East Claydon Parish Council

Application by Rosefield Energyfarm Limited for an Order Granting Development Consent for the Rosefield Solar Farm (EN010158)

Comments on Deadline 6 Submissions

EN010158/APP/6.3.4

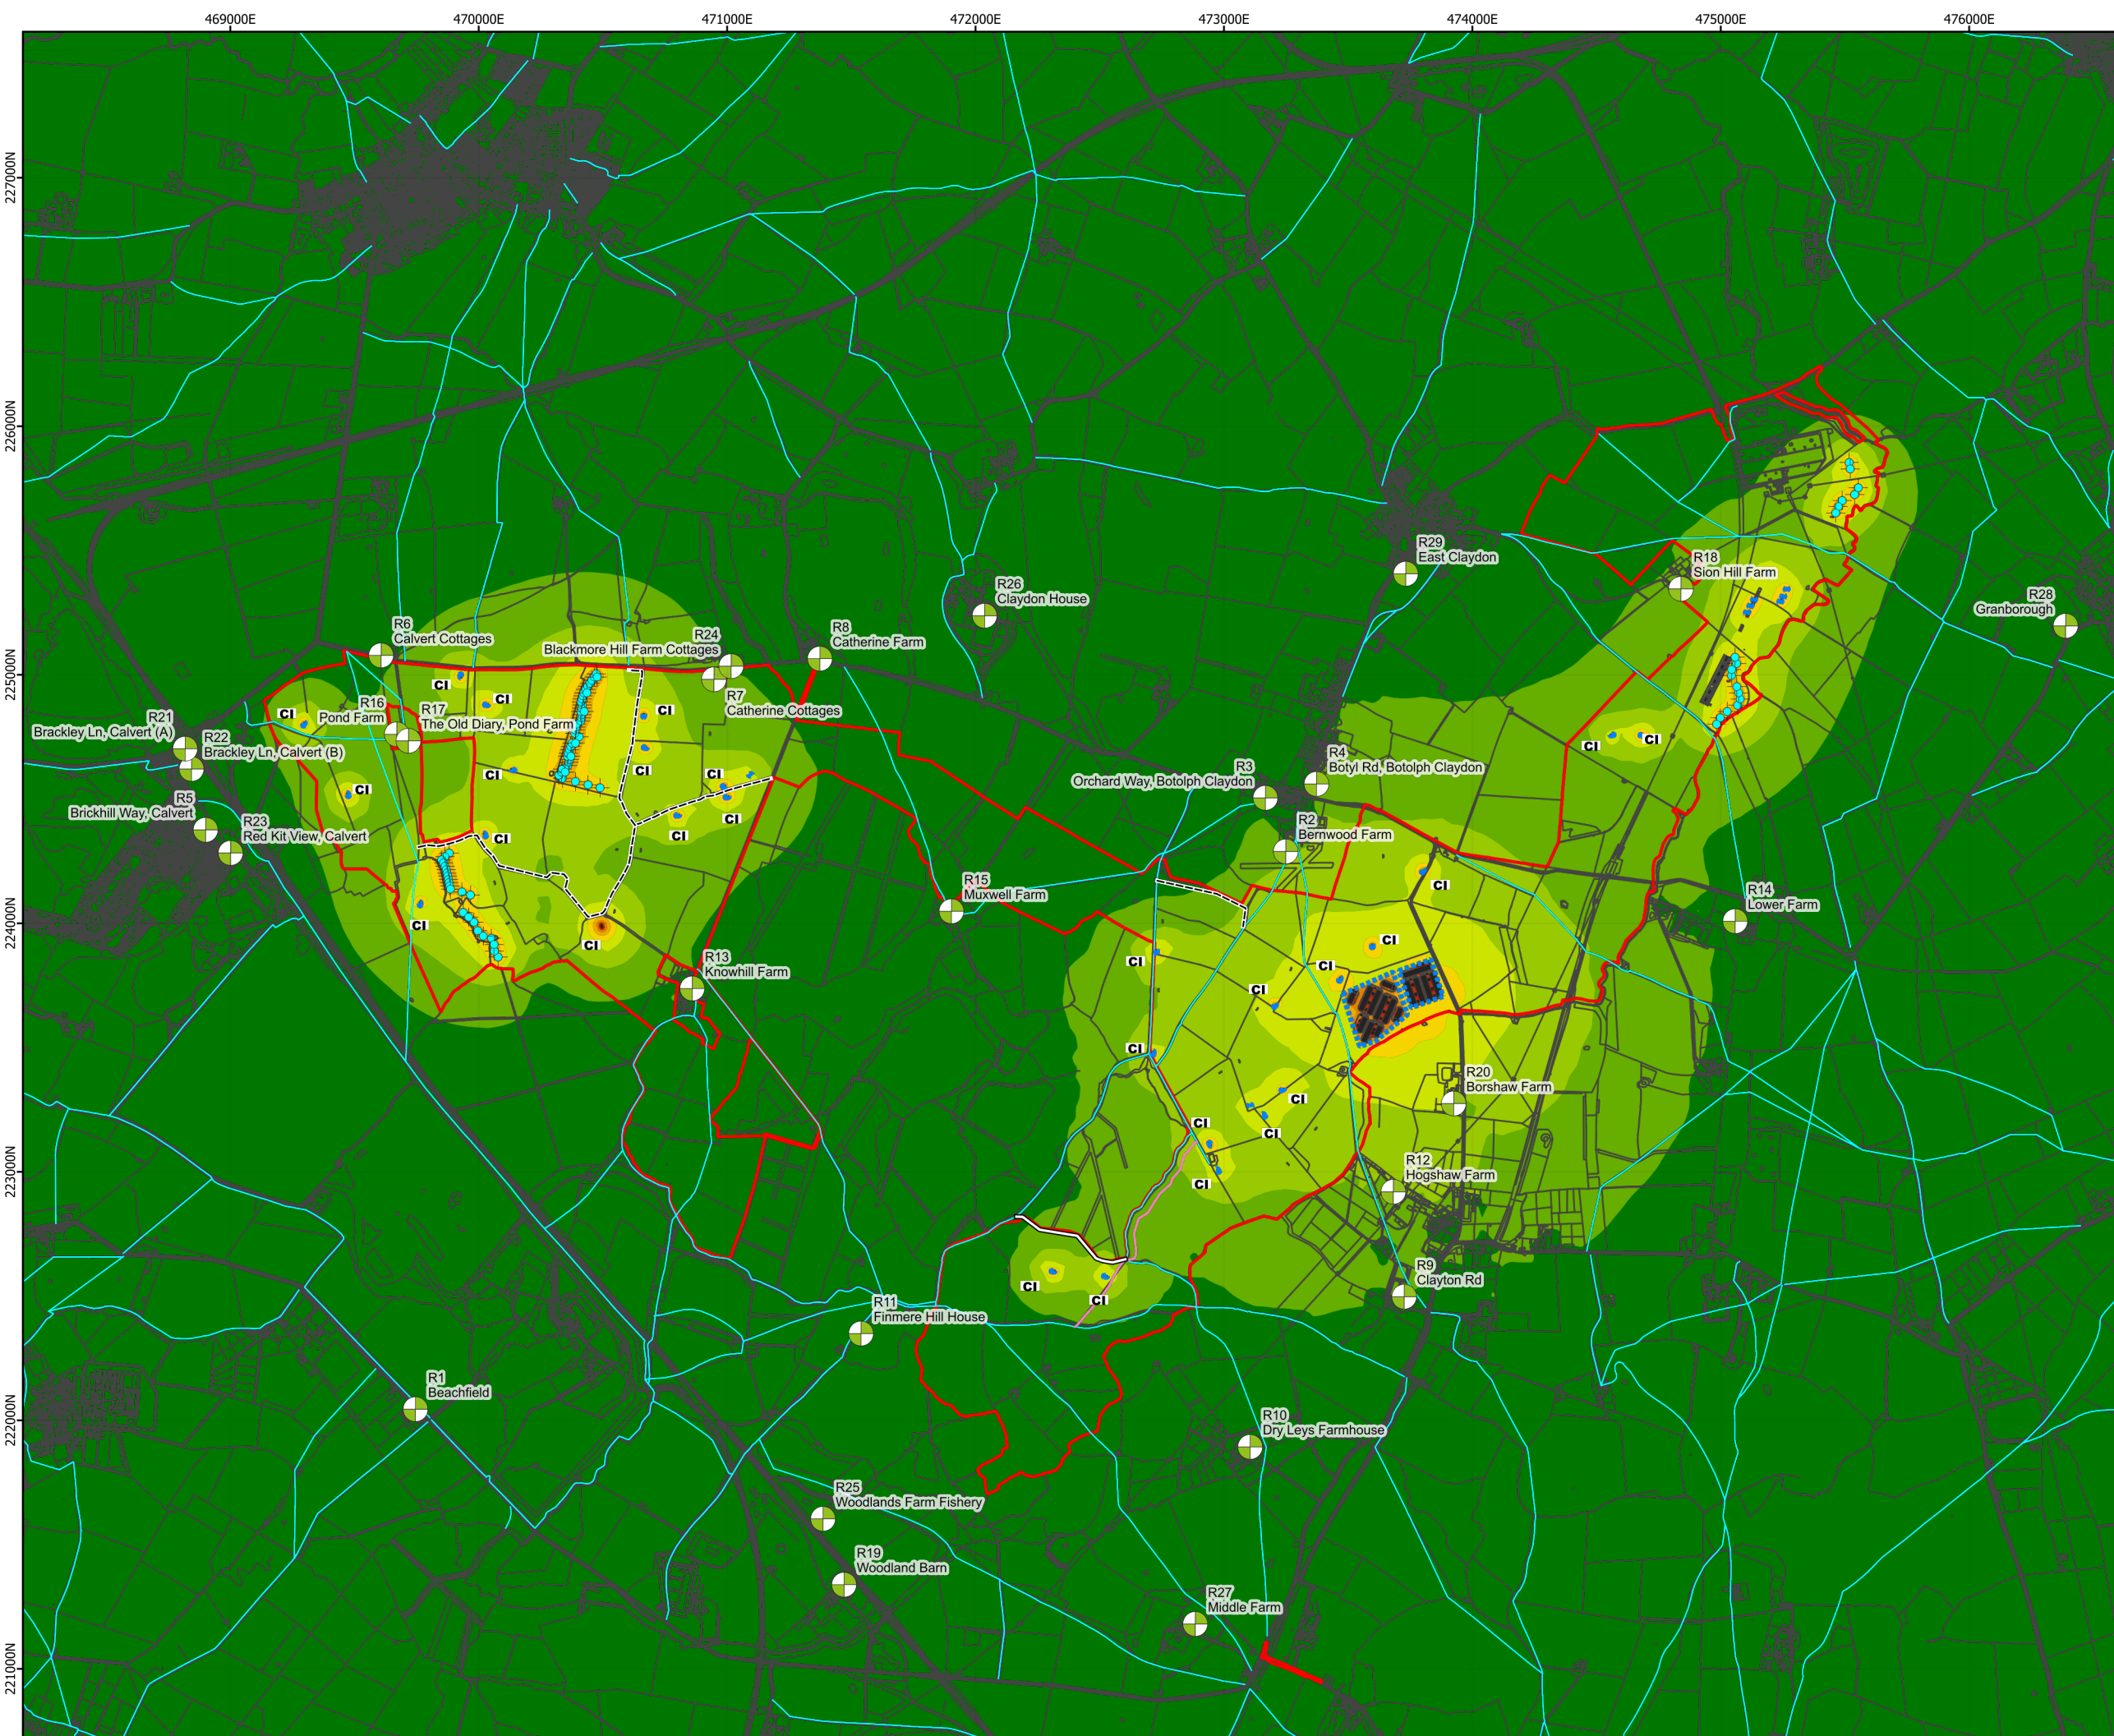
REP6-070 (3.26) [Noise disturbance]	Regarding noise the Applicant has further stated that, " <i>A range of mitigation measures have been proposed within ES Volume 2, Chapter 13: Noise and Vibration [EN010158/APP/6.2.5] and the Outline CEMP [EN010158/APP/7.2.7] to address the potential for significant adverse effects during the construction phase, at a limited number of receptors.</i> "	The Applicant's assessment of noise continues to be restricted to ' <i>a limited number of receptors</i> ' whereas from experience of other infrastructure projects across the area, we are very much aware that the level and extent of noise disturbance far exceeds that predicted by the developer.
